Ribble Valley Borough Council

App No: 3.2025.0588

Location: Land east of Clitheroe Road, Whalley

Proposal: Proposed erection of 77 no. affordable dwellings with associated access, gardens, parking and landscaping areas.

Draw: Name & Location: 21/03/2025 09:34:124 P: Pringle Homes - Site at Clitheroe Road, WhalleyDrawingNumber: 24-124-0001 Project: Proposed Site Layout Rev: E.dwg

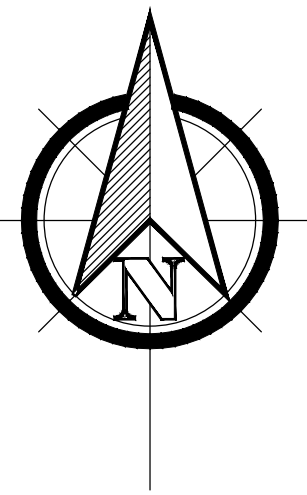
The surface water is proposed to be connected to a piped system in Clitheroe Road which appears to be a highway drainage system. This does not comply with the Lancashire County Council policy as no connections into any highway drainage system are allowed.

There is attenuation storage proposed beneath the estate road close to plots 41-42. This does which does not comply with Lancashire County Councils adoptable standards and we would request that this is relocated from beneath the estate road onto the private shared driveway/parking area.

The estate road is proposed at 5.5m wide with 2m wide footways to both sides. Swept path analysis for a 11.2m long refuse wagon is provided. Since our initial discussions we have increased our carriageway width guidance to 6m initially at the junction of the major road into the site. We would request that this minor amendment is made.
